Dáta | Date
25 May 2026

Ár dTag | Our Ref.
TII26-135842

Re: Strategic Infrastructure Development Application for the Proposed Carrigeen Renewable Energy Development including 11 wind turbines and associated works, County Roscommon

ACP case ref. PAX20.324167

Figure 16.3: the Grid Connection

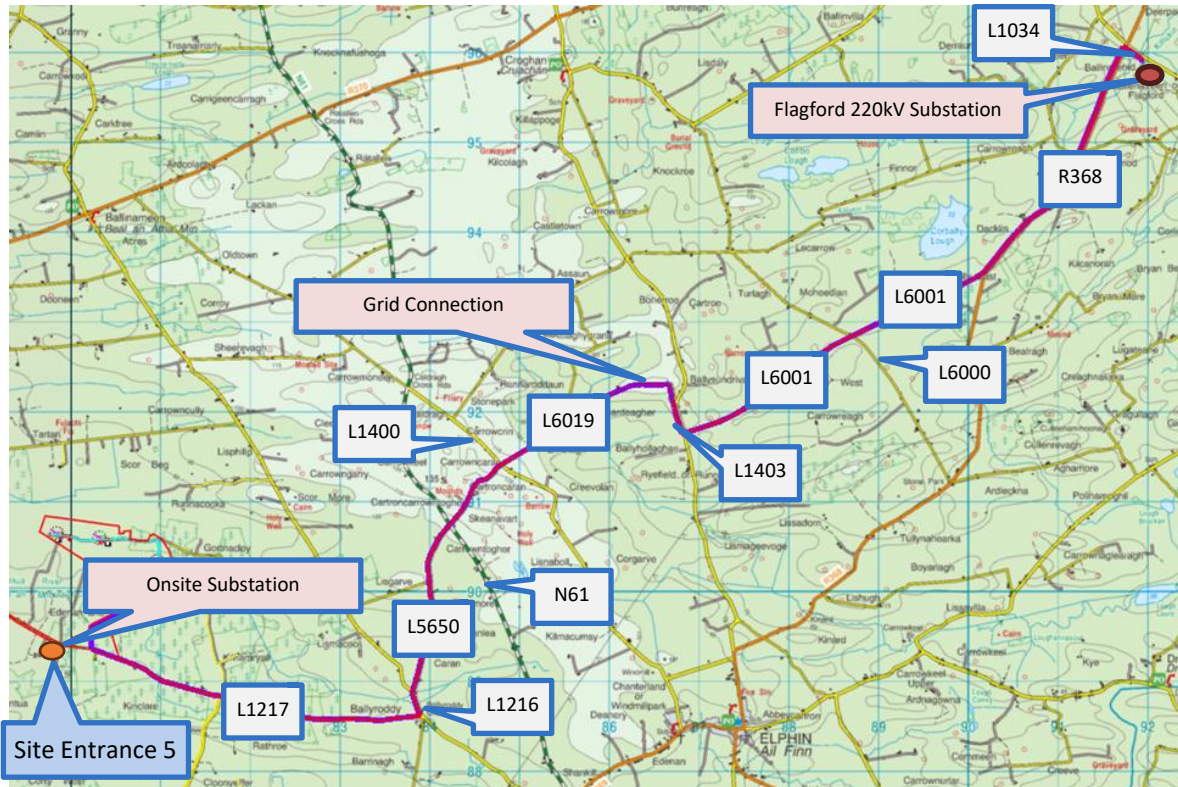
In relation to the specific application, proposals for a c. 17.5km grid connection cable routing between the proposed on-site Substation and the Flagford 220kV substation, the national road interactions include a crossing of the N61 outlined as being by 110kV cable trench in the public road.

Having regard to the measures identified in CAP24 and the information in relation to grid routing included in the subject application, TII recommends that the Commission be satisfied that the proposed grid routing represents the optimal routing solution.

'Crossings of the N61 national road network shall be by HDD only. All standards for grid connection cable construction and associated infrastructure in the public road shall be agreed with the Road Authority prior to the commencement of any development.'

**Figure 16.5: Turbine Delivery Route**

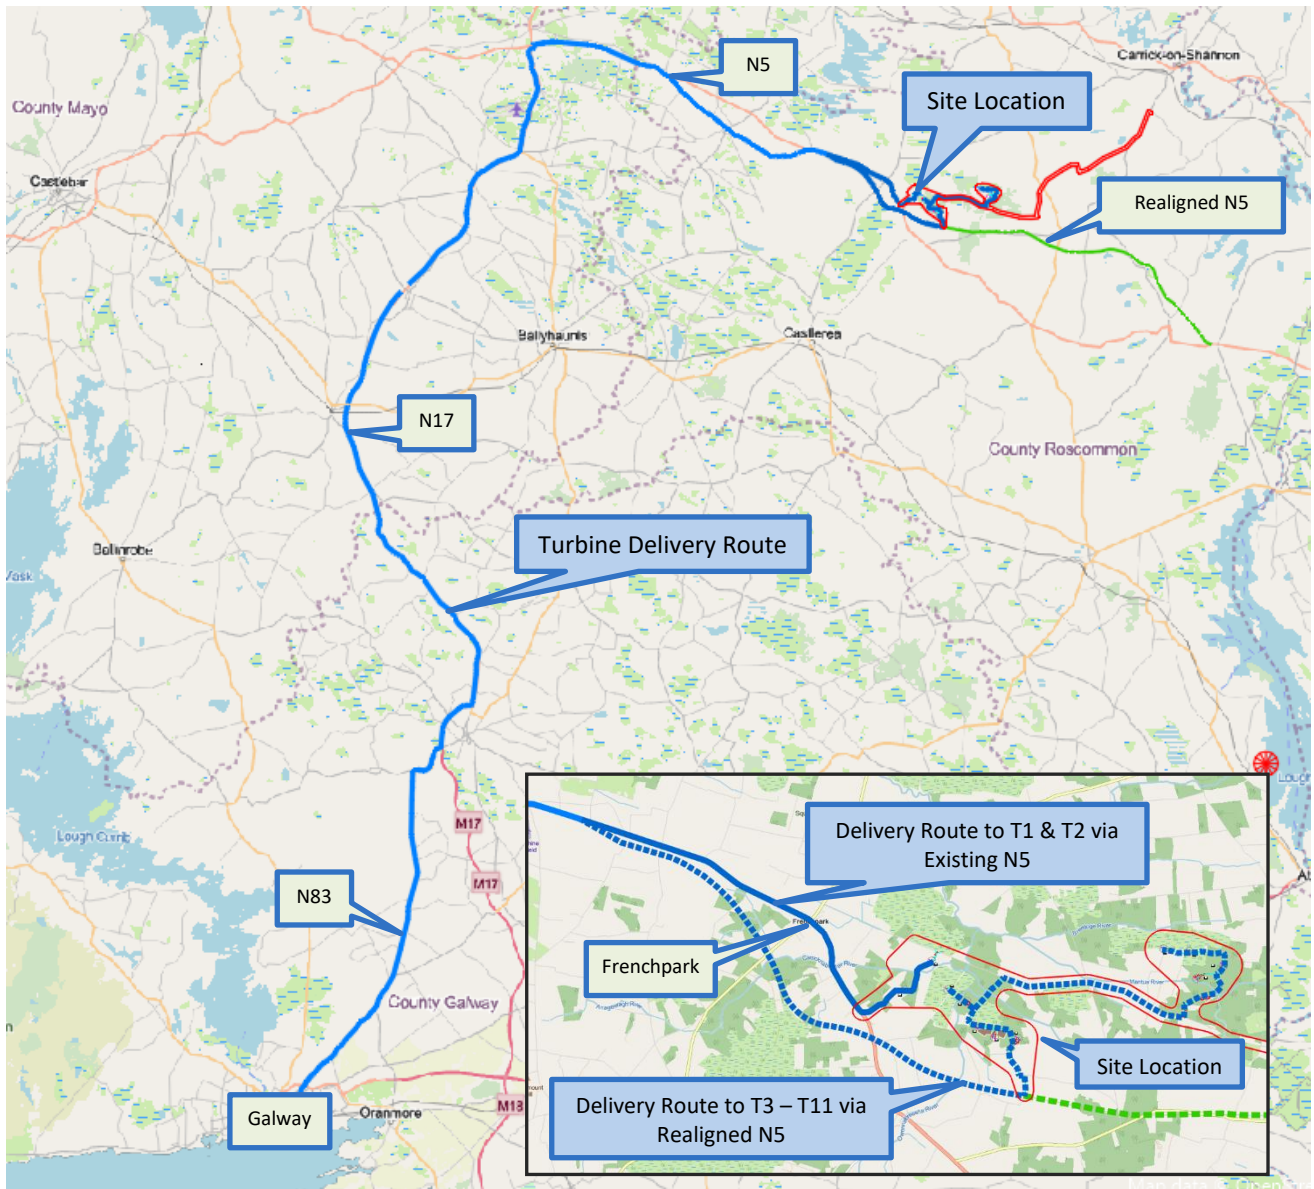
Section 16.2.10 of the EIAR submitted in support of the subject application addresses the Turbine Delivery Route and Enabling Works. The EIAR outlines a proposed delivery route from port of entry Galway utilising N6, N83, N17, and N5, national roads to site.

Enabling works impacting the national road network are outlined in the EIAR and include N5 / Realigned N5 Tie-in west of Frenchpark; construction of an abnormal load delivery access road to allow abnormal load vehicles to access the redundant section of the N5 leading to Frenchpark from the realigned N5. Appendix 16.3 'Turbine Delivery Haul Route Assessment' also refers and Section 3.13 outlines proposals to realign N5 to Existing N5, Frenchpark.

- The proposed temporary works to the N5 national road (new realigned and existing) in order to accommodate abnormally sized loads are for a temporary period only to facilitate turbine component and, where warranted, substation component delivery to site and thereafter temporary works shall be removed and lands reinstated following completion of the construction phase of development in the interests of road safety and adherence to the provisions of official policy.

- The proposed temporary enabling works to the N5 junction should be closed off with a temporary safety barrier when not in use for turbine component delivery, as it could be misinterpreted by drivers as part of the roadway. Pending completion of construction, the temporary works shall thereafter be permanently closed and the lands reinstated.
